WEST SUSSEX COUNTY COUNCIL CONSULTATION

TO:	Arun District Council FAO: Maria Tomalova
FROM:	WSCC - Highways Authority
DATE:	20 April 2020
LOCATION:	Babsham Business Centre, Babsham Lane, Bersted PO21 5EL
SUBJECT:	BE/89/19/PL The change of use of land for the storage of building materials, equipment & plant & for the parking of fixed body vehicles together with part boundary screen fence. Amended drawings received.
DATE OF SITE VISIT:	n/a
RECOMMENDATION:	Advice
S106 CONTRIBUTION TOTAL:	n/a

PROPOSED SITE PLAN - 1:200

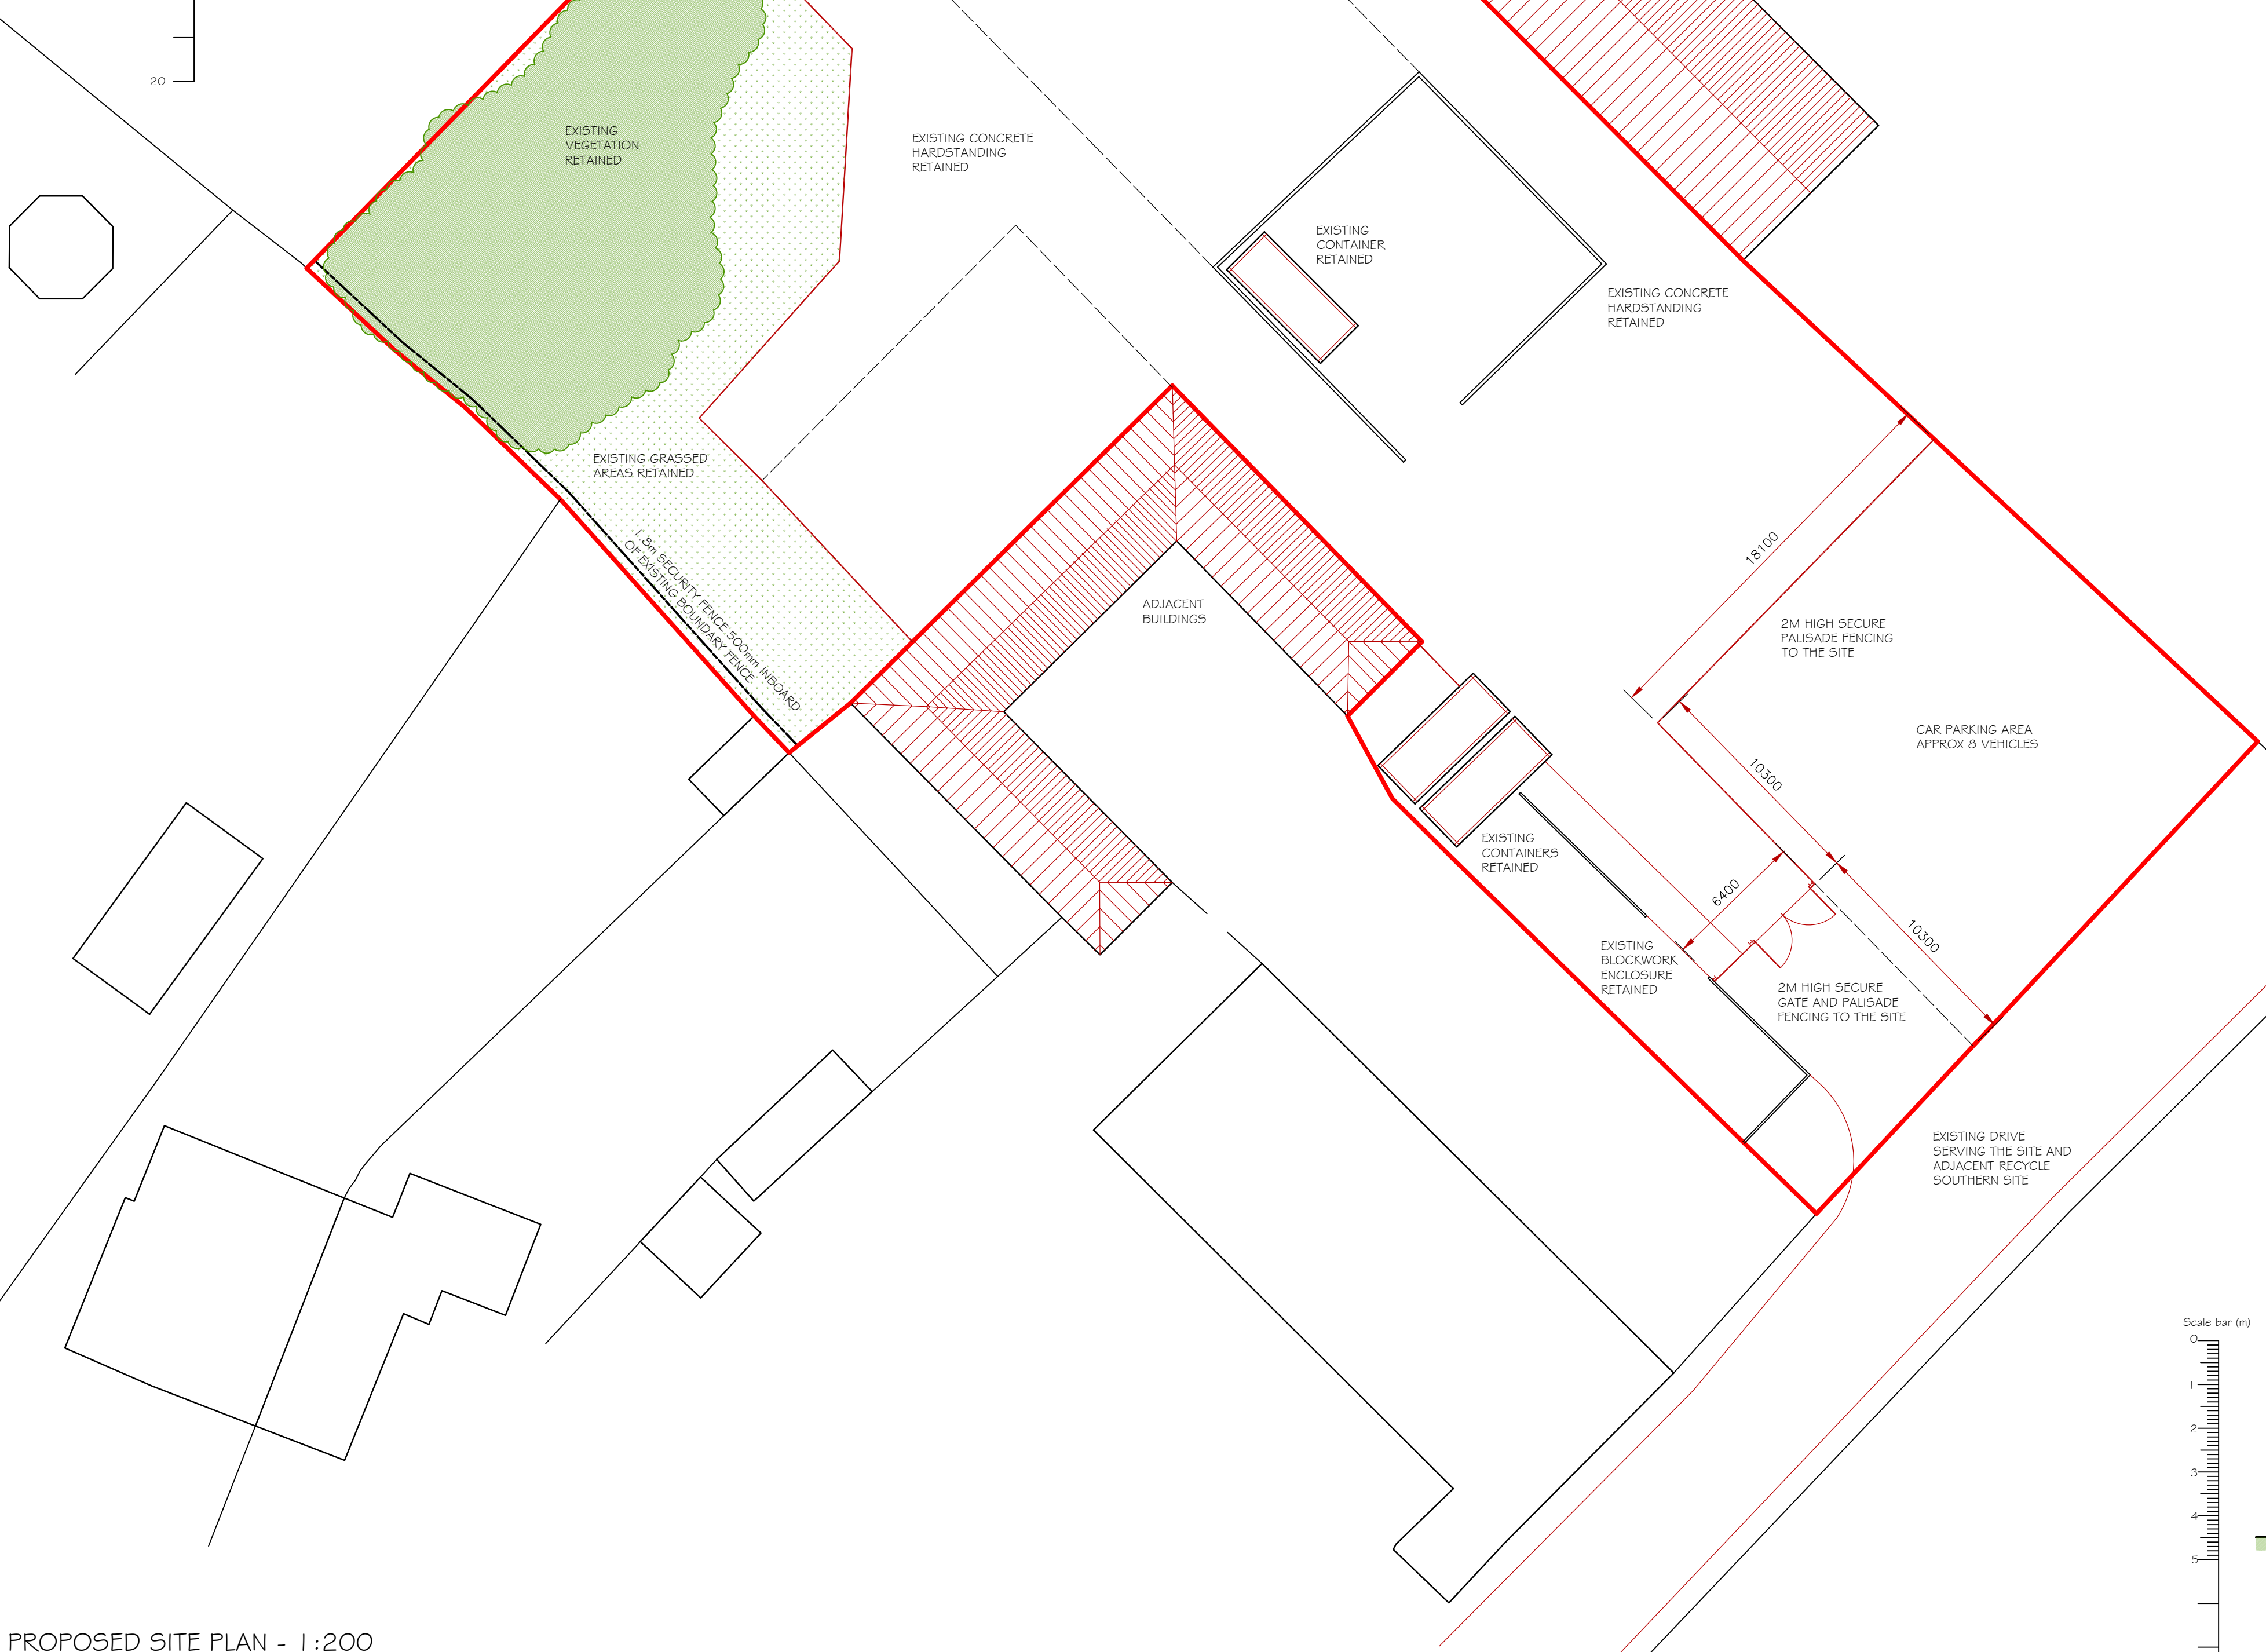
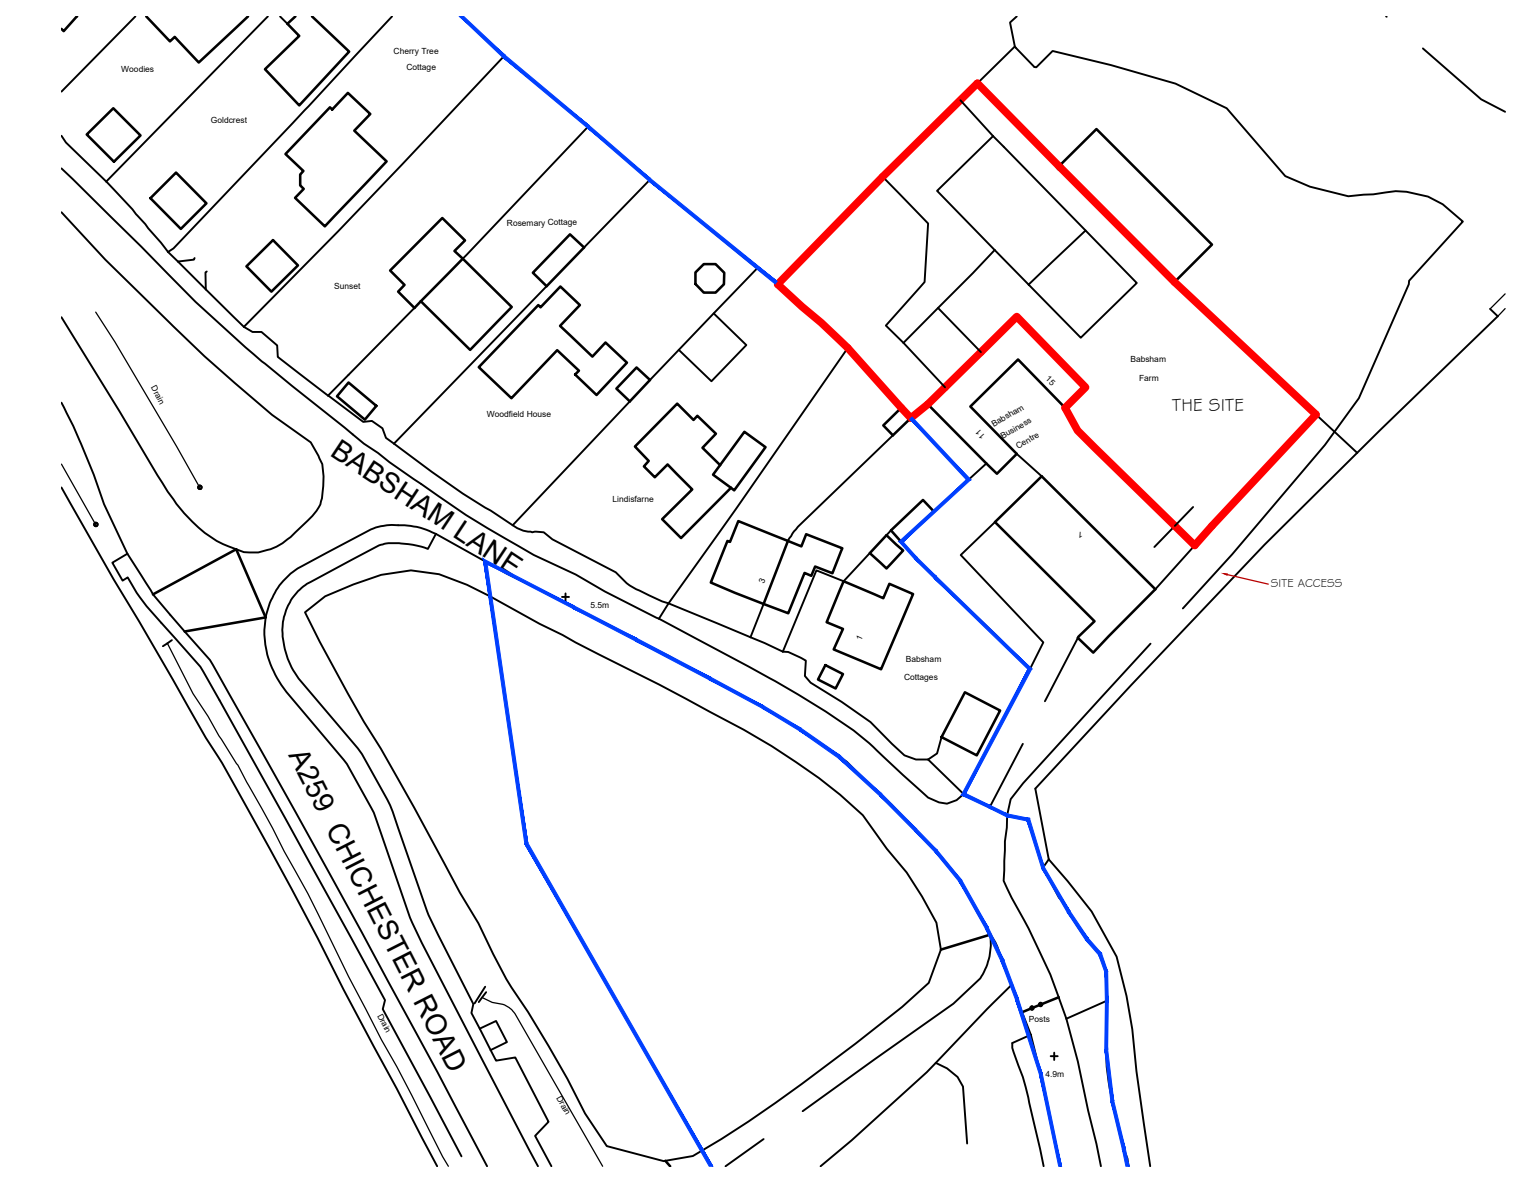
The LHA was originally concerned that, whilst the site has been operating storage of HGVs since 2010 without any evidence of highway safety concern, the proposed gate (originally not demonstrated on the plans) would potentially obstruct the ability for HGVs to manoeuvre to and from the site, and as such HGVs would not be able to access the parking area or turn on site. This could then potentially have resulted in HGVs being required to reverse onto the publicly maintained highway and cycle route. Following submission of the revised plan indicating that the proposed gate location is not obstructing the parking area and clarification that the parking area will not serve HGVs and HGVs will not be stored on the site, I would not anticipate that the LHA could substantiate an objection to the application on this basis.

The proposed parking area demonstrated on the revised site plan is intended to provide parking for approximately 8 fixed body vehicles. Whilst the ability for these vehicles to turn on site may be reduced if the parking area is full, it is anticipated that vehicles will be able to turn within the private access way and exit onto the public highway in a forward gear. As such the LHA would not anticipate a highway safety concern in regards to this proposal.

If the LPA are minded to approve the application, a standard condition securing vehicle parking would be advised.
